LAND WEST OF B2132 BILSHAM ROAD, YAPTON

**STAGE 1 ROAD SAFETY AUDIT DESIGNERS RESPONSE
DROVE LANE SITE ACCESS**

**STAGE 1 ROAD SAFETY AUDIT DESIGNERS RESPONSE
A259 OYSTERCATCHER IMPROVEMENT SCHEME**

Scale 1:500 @A1	Date DEC 17	Designed SD
Drawn SD	Checked MS	Approved R.JH
Job No 14-111	Drawing No 14-111/202	Rev

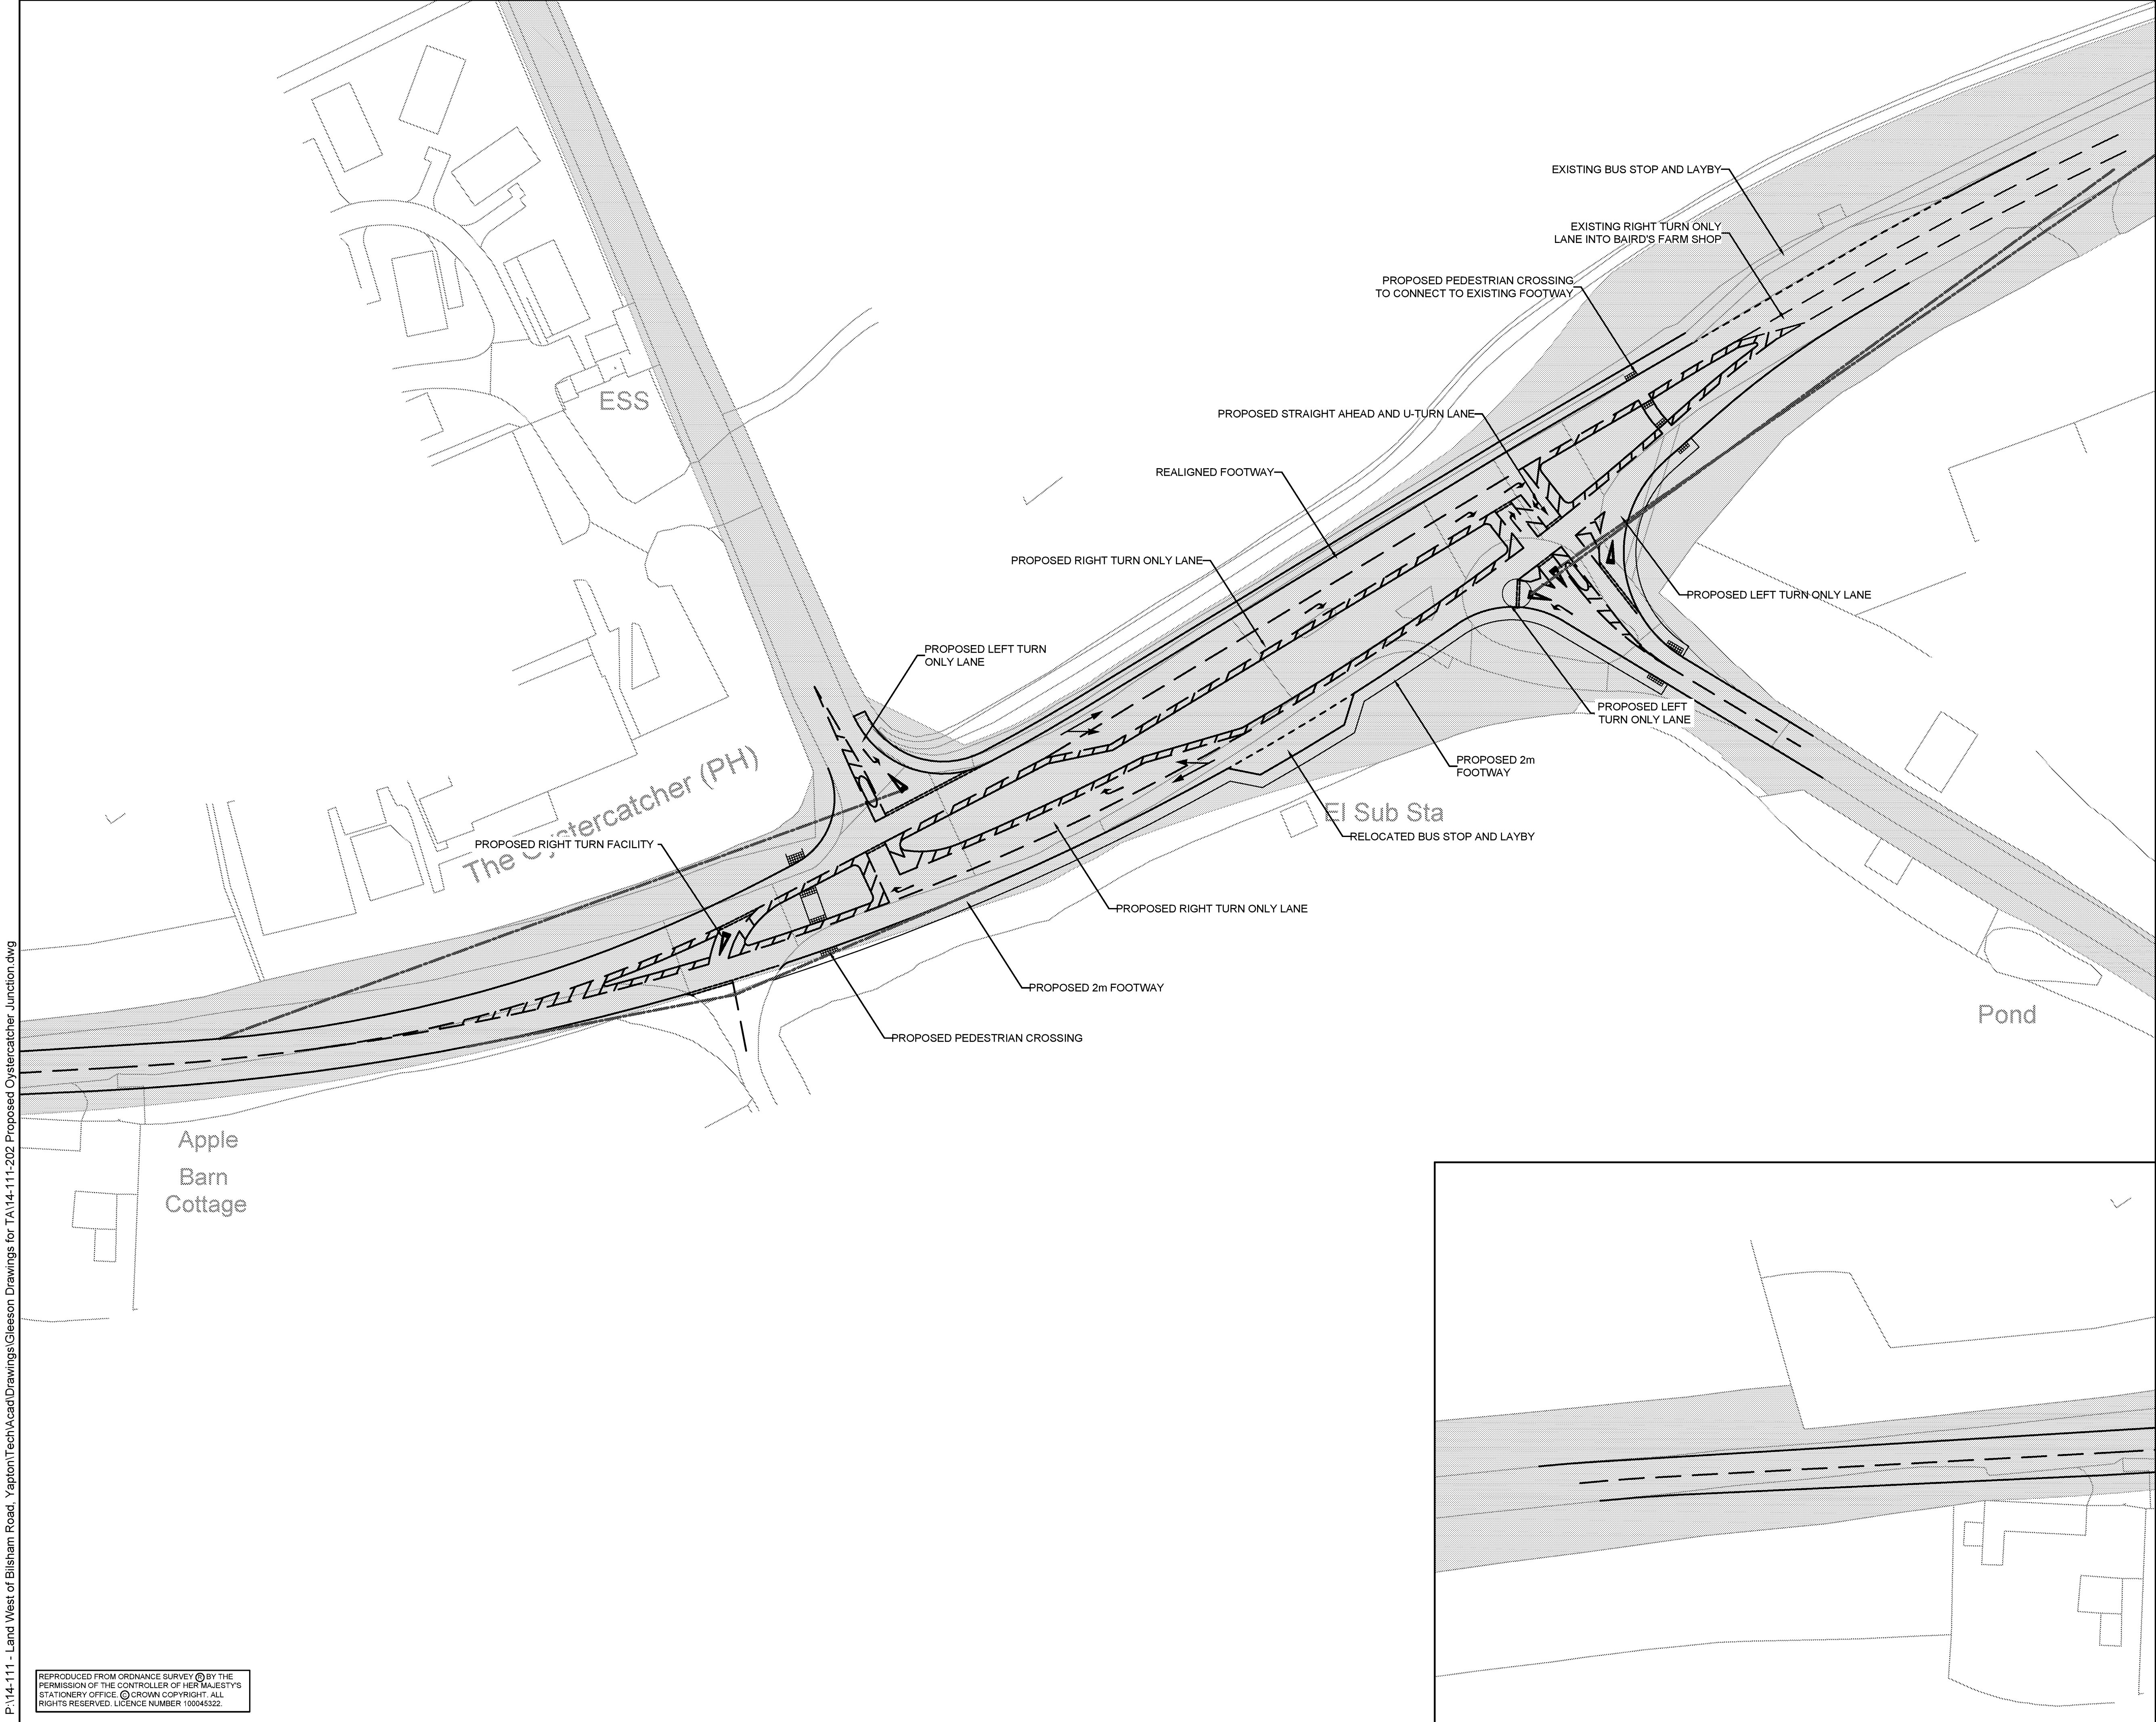
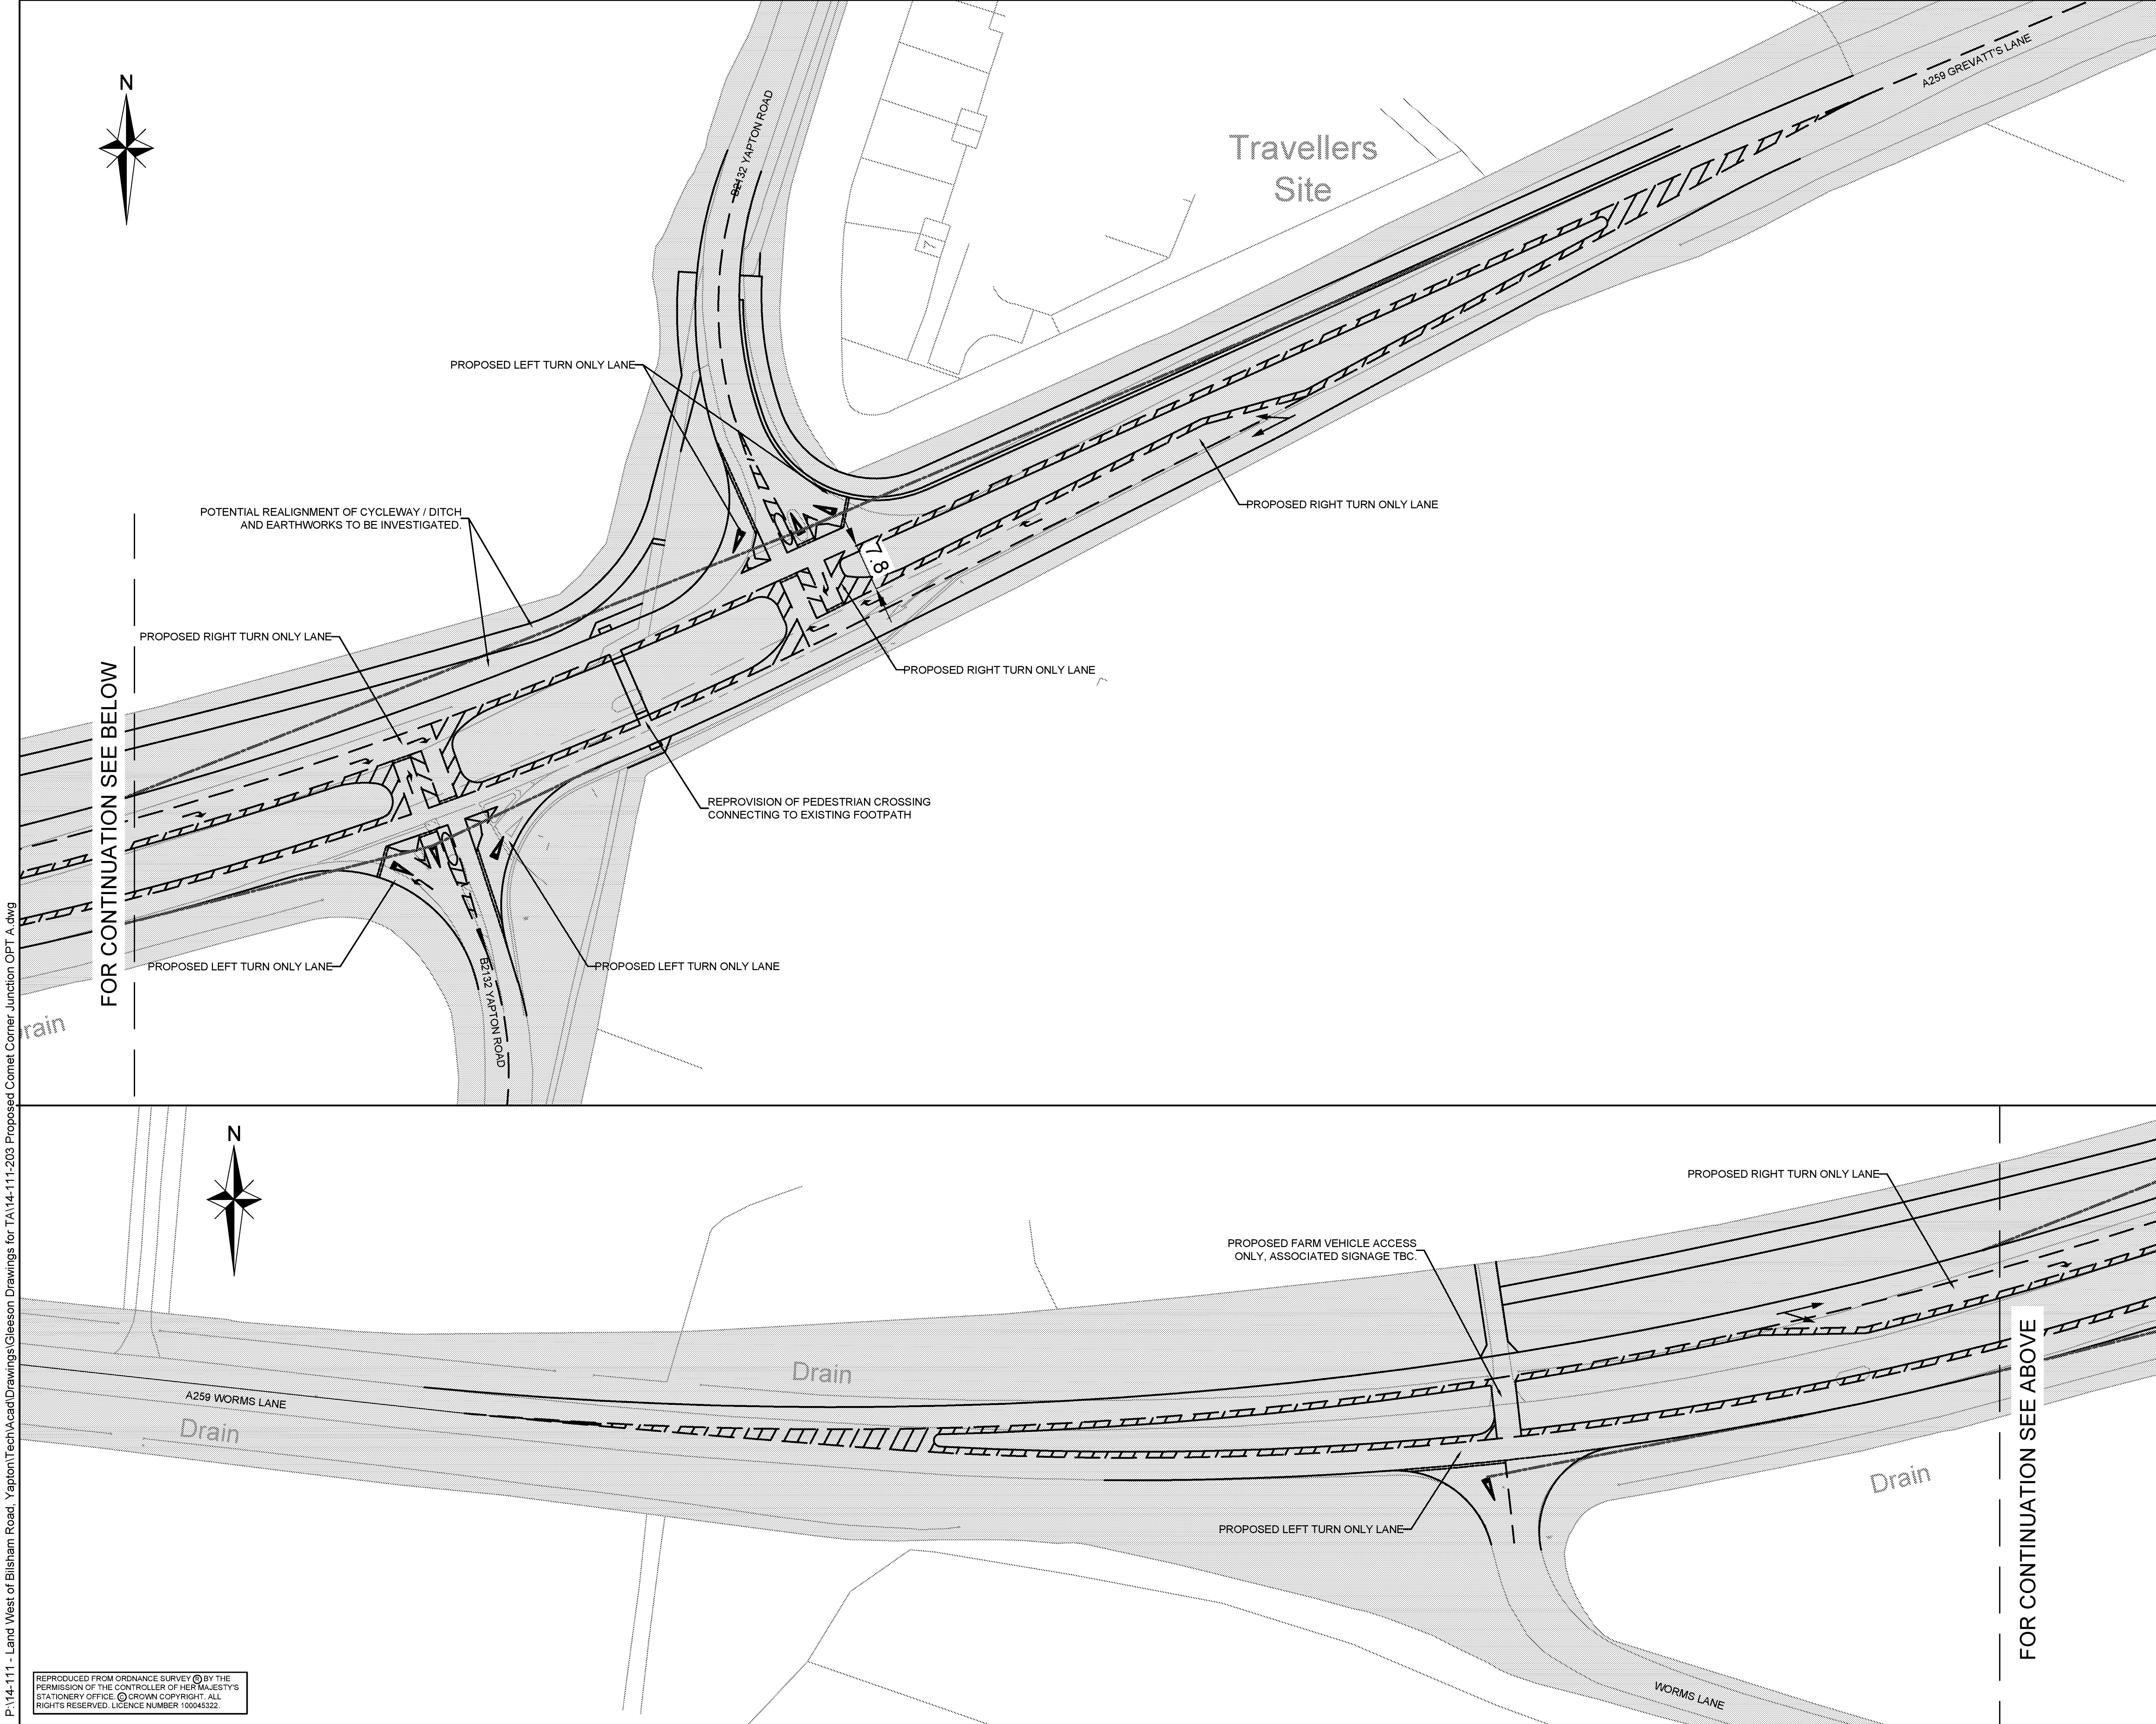
3.1	The removal of the acceleration lanes on to the A259 will result in vehicles having to join the main carriageway from a stationary position. This could increase the risk of vehicles attempting to join the A259 being struck in the rear by traffic already on the A259.	Retain the acceleration lanes.	As part of the proposals the speed limit will be reduced to 40mph. A full DMRB standard visibility splay of 2.4m x 120m is easily attainable on the Climping Street arm. The need to retain the acceleration lane is therefore unnecessary.
Location	A259/Climping Street

3.2	The introduction of the central median will result in traffic wishing to travel west from Yapton Road having to carry out a U-turn manoeuvre at the A259/Climping Street junction. The limited space may result in large cars being unable to carry out the manoeuvre in one	Review the junction arrangements to provide a safe U-turn facility.	A swept path assessment has been undertaken using an agricultural vehicle and trailer to demonstrate that a large vehicle can turn within junction (see Drawing 14-111/###). It is also noted that Climping Roundabout is c.650m east of the proposed junction allowing large vehicles to easily U-turn if required to travel west along the A259.

movement increasing the risk of collisions with westbound traffic on the A259 or right turning vehicles from Climping Street. This problem will be exacerbated with larger vehicles. Drivers may also drive to Bairds Farm Shop to carry out the U-turn which may increase the risk of collisions with other road users.		
Location	A259/Climping Street

3.3	Vehicles exiting the A259 into Climping Street have to give way to traffic turning into the junction from the west. This could, during peak periods, result in left turning traffic waiting to turn into Climping Street queuing back on to the A259 (East) increasing the risk of tail-end shunts.	Provide adequate stacking space to accommodate any queues of left turning traffic.	The right turning lane from the A259 to Climping Street has a length of 14m leaving space for two PCU's (5.75m) to wait at the giveaway line. It is also noted that vehicle turning count surveys at the existing junction show just 10 vehicles turn into Climping Street in the AM peak and 12 in the PM peak hours from both the east and west. This will see very little increase in traffic up to the 2031 future assessment year with 12 vehicles in the AM peak and 14 in the PM peak. This equates to 1 vehicle every 4.5 minutes, the likelihood of vehicles queueing back into the main carriageway is therefore very remote.

Location	A259		
3.4	The proposed pedestrian crossing facility to the east of Climping Street is unlikely to be used by pedestrians travelling to and from Yapton	Provide a suitable pedestrian crossing facility on the A259 between Climping Street and Yapton Road.	Accepted. A crossing has been added west of the B2233 Yapton Road. A new footway has also been added to the proposals on the southern side of the A259 between the bus stop and the access to the Paintball facility.

Road as it involves a lengthy diversion. This may lead to pedestrians attempting to cross at the central median between Yapton Road and Climping Street where drivers may not be expecting them to cross. This could result in vehicle/pedestrian collisions.		It is noted that WSCC are currently constructing a new shared footway / cycleway along the northern side of the A259 from Climping to Felpham. The proposed crossing has been designed to tie in with this new facility see Drawing 14-111/004-A
Location	A259/Unnamed lane to Paint Ball

3.5	The introduction of the A259 central median will restrict the right turn manoeuvre to and from the lane. This could lead to traffic undertaking injudicious maneuvers to carry out a U-turn increasing the risk of collisions with traffic on the A259.	Review the junction arrangements to provide a safe U-turn facility.	Agreed. A right turn lane has been added to allow vehicles exiting the paintball facility to head east without having to perform a U-turn maneuver. See Drawing 14-111/004-A
